PORT KEMBLA COPPER STACK DEMOLITION WASTE MANAGEMENT PLAN

I am writing in response to your request for comments from the Environment Protection Authority (EPA) on 2 December 2013 regarding the adequacy of the "Waste Management Plan" prepared by Port Kembla Copper (PKC). This plan formed part of the revised Stack Demolition Management Plan (SDMP).

Figure 4: PKC's Proposed Dust Suppression Network

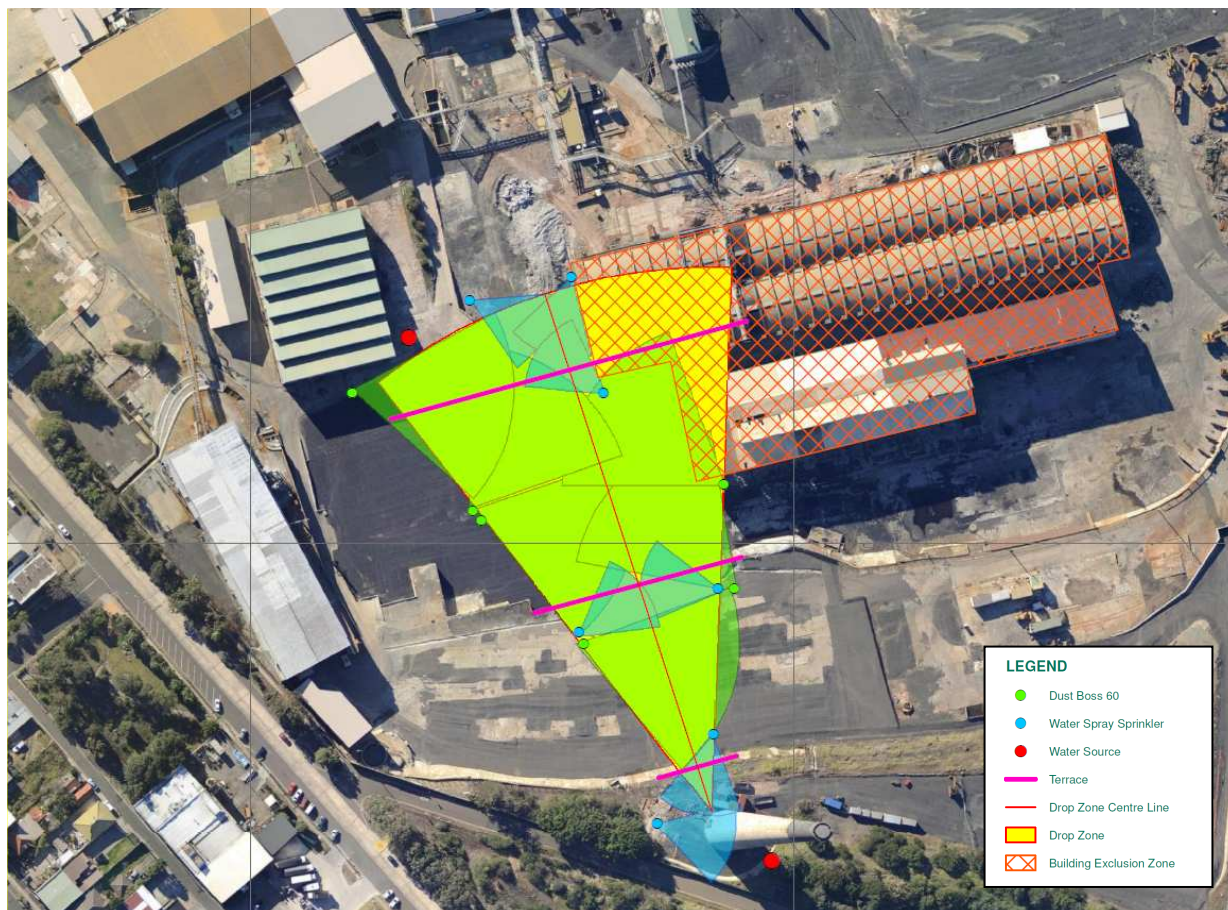
4. Dust controls during crushing and rubble handling/emplacement/disposal will be very important and need to be described. This is especially true for any material containing refractory bricks given the presence of heavy metals and the potential presence of crystalline silica. As stated above, these bricks are likely to require a higher degree of environmental controls than the concrete. PKC should identify the crushing methodology for each waste stream and describe the associated environmental controls. This should include but not be limited to use of water sprays for dust control, whether the waste can be crushed safely outside, or if crushing will be carried out inside a building such as the existing Bulk Concentrate Shed (as previously stated by PKC in the SDMP).
